Project Name : Land West of B2132 Bilsham Road

Job No. : 14-111

Note Title : Response to WSCC Highways Comments

Date : February 2018

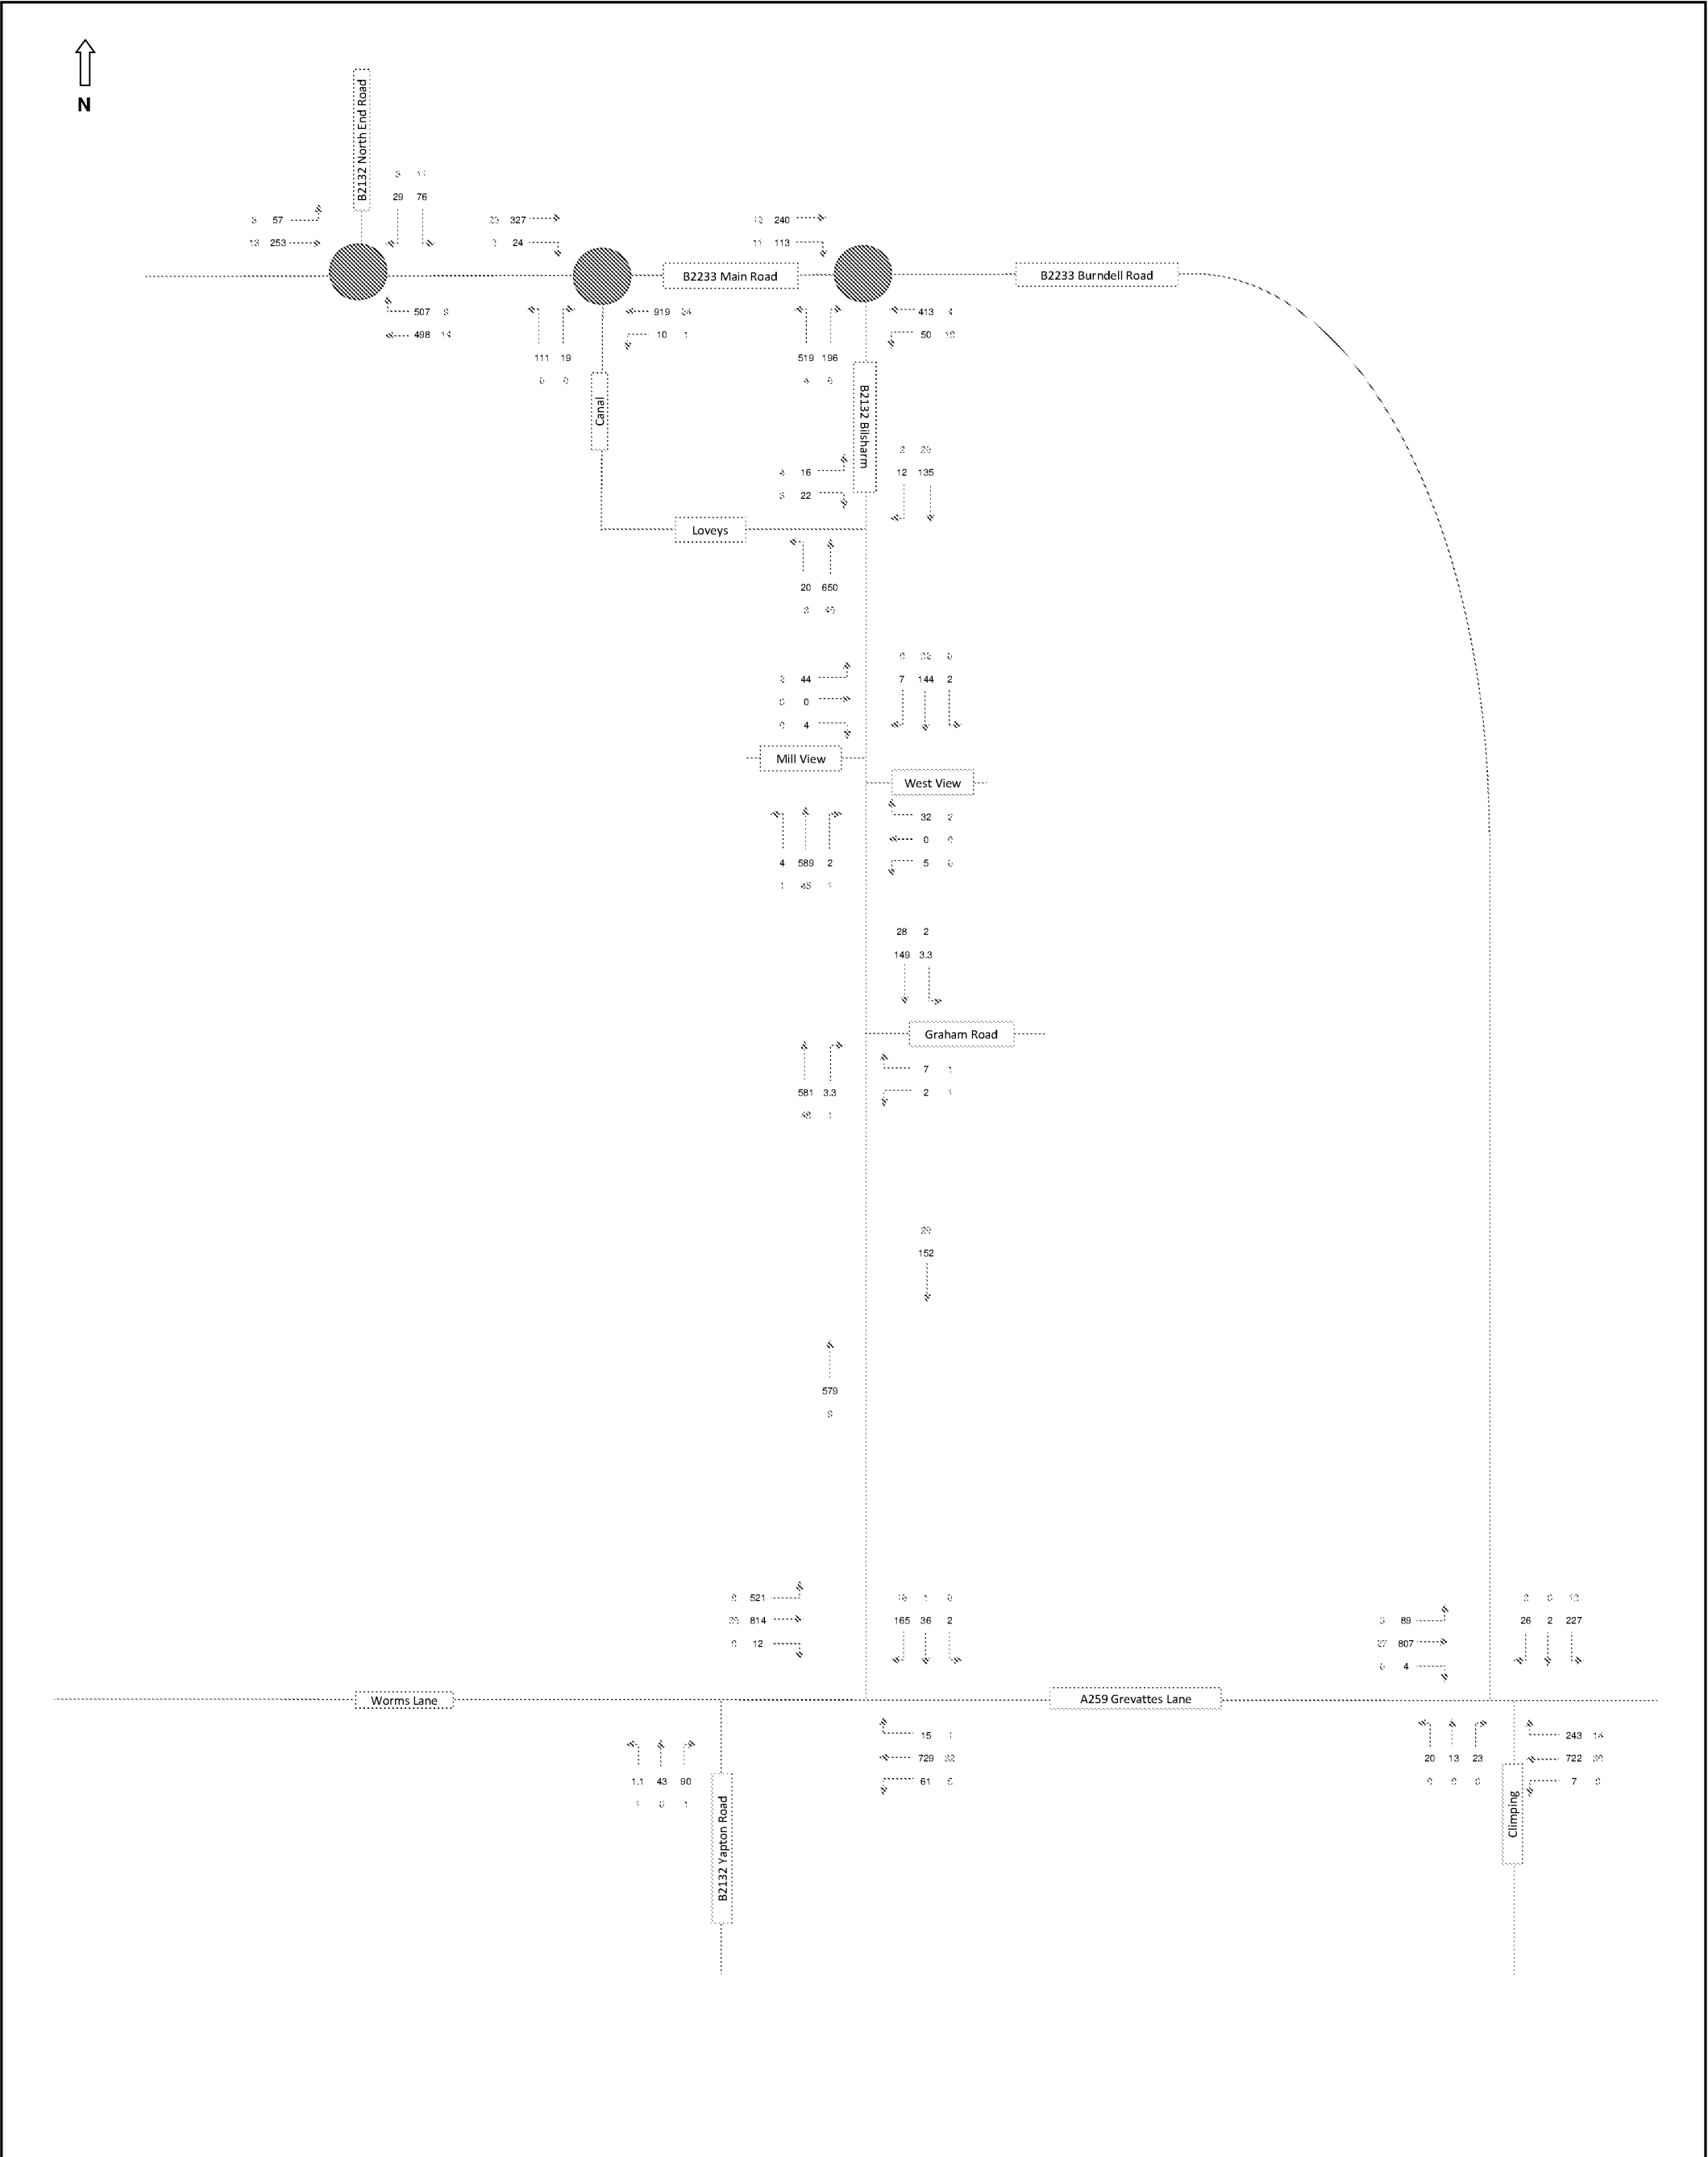
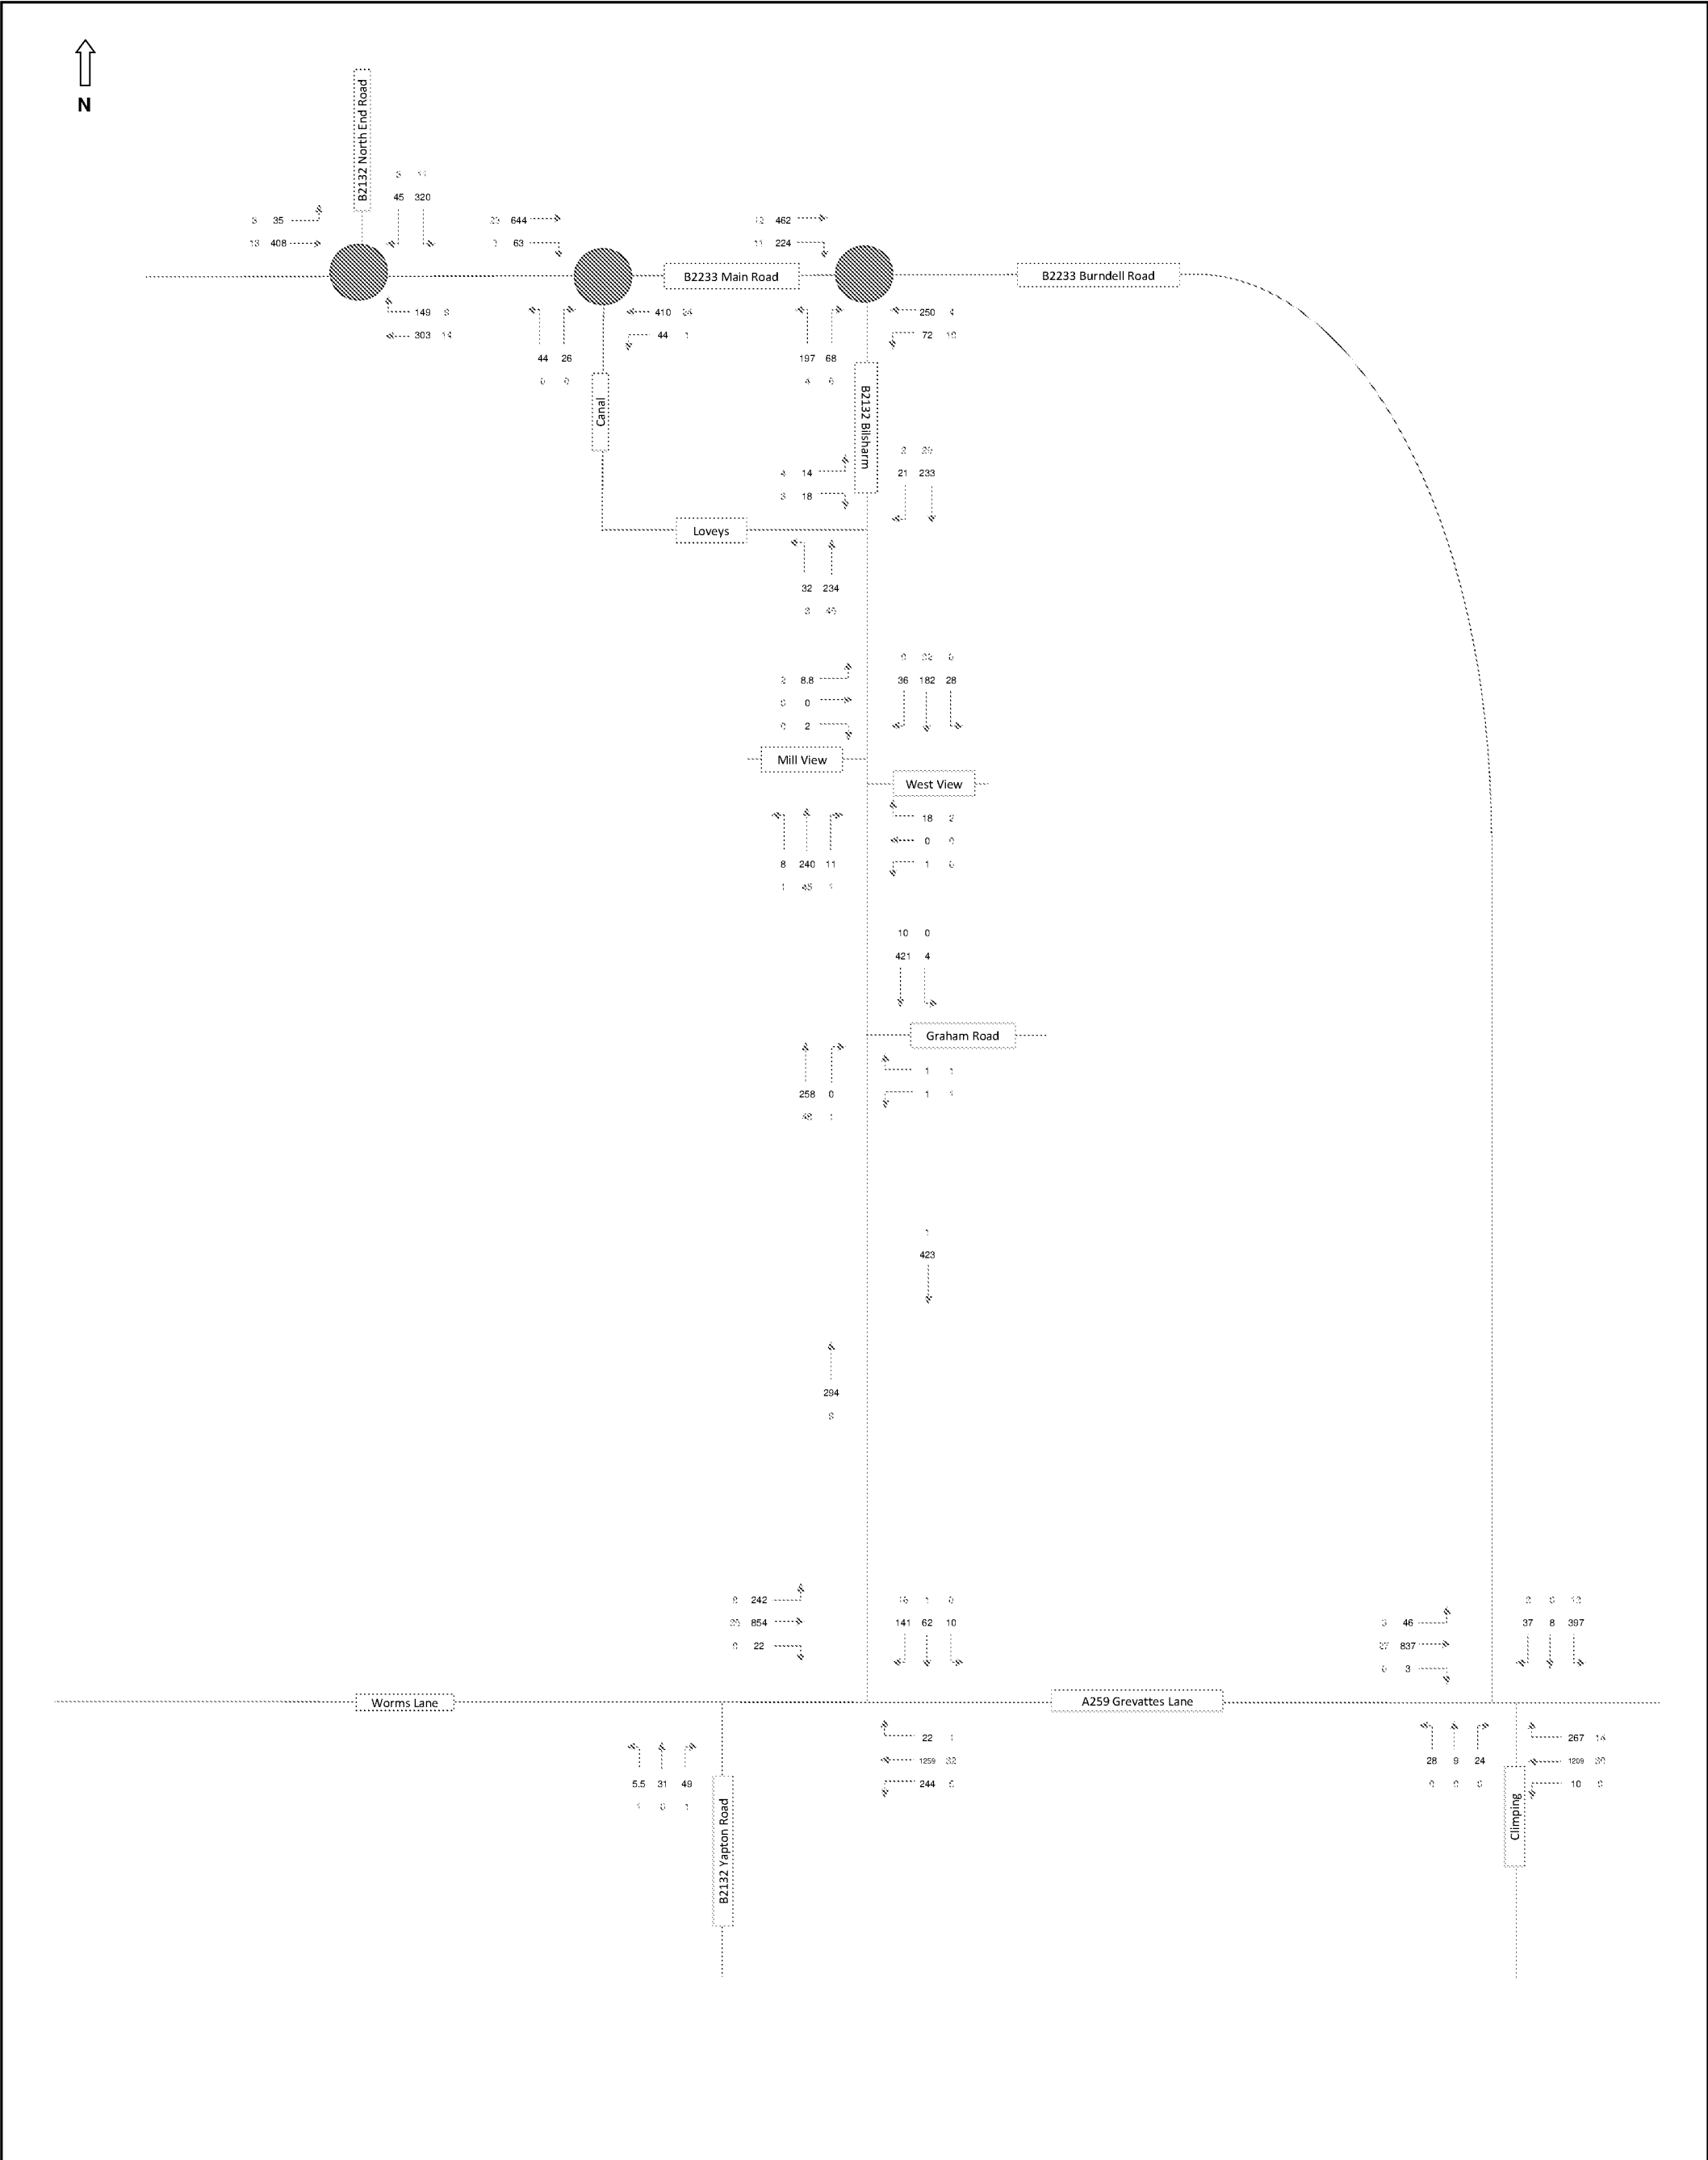
- 2.6 WSCC have also requested additional information relating to the distribution and assignment of development traffic on the local highway network.

“Within the pre-application discussions it was requested that information would be required to confirm the assumption utilised in the production of the gravity model and the subsequent distribution. This has not been provided.”

- 2.11 For clarity additional traffic flow diagrams have been included in **Appendix C** of this TN. These show the percentage and number of development traffic vehicles assigned and distributed to the local highway network.
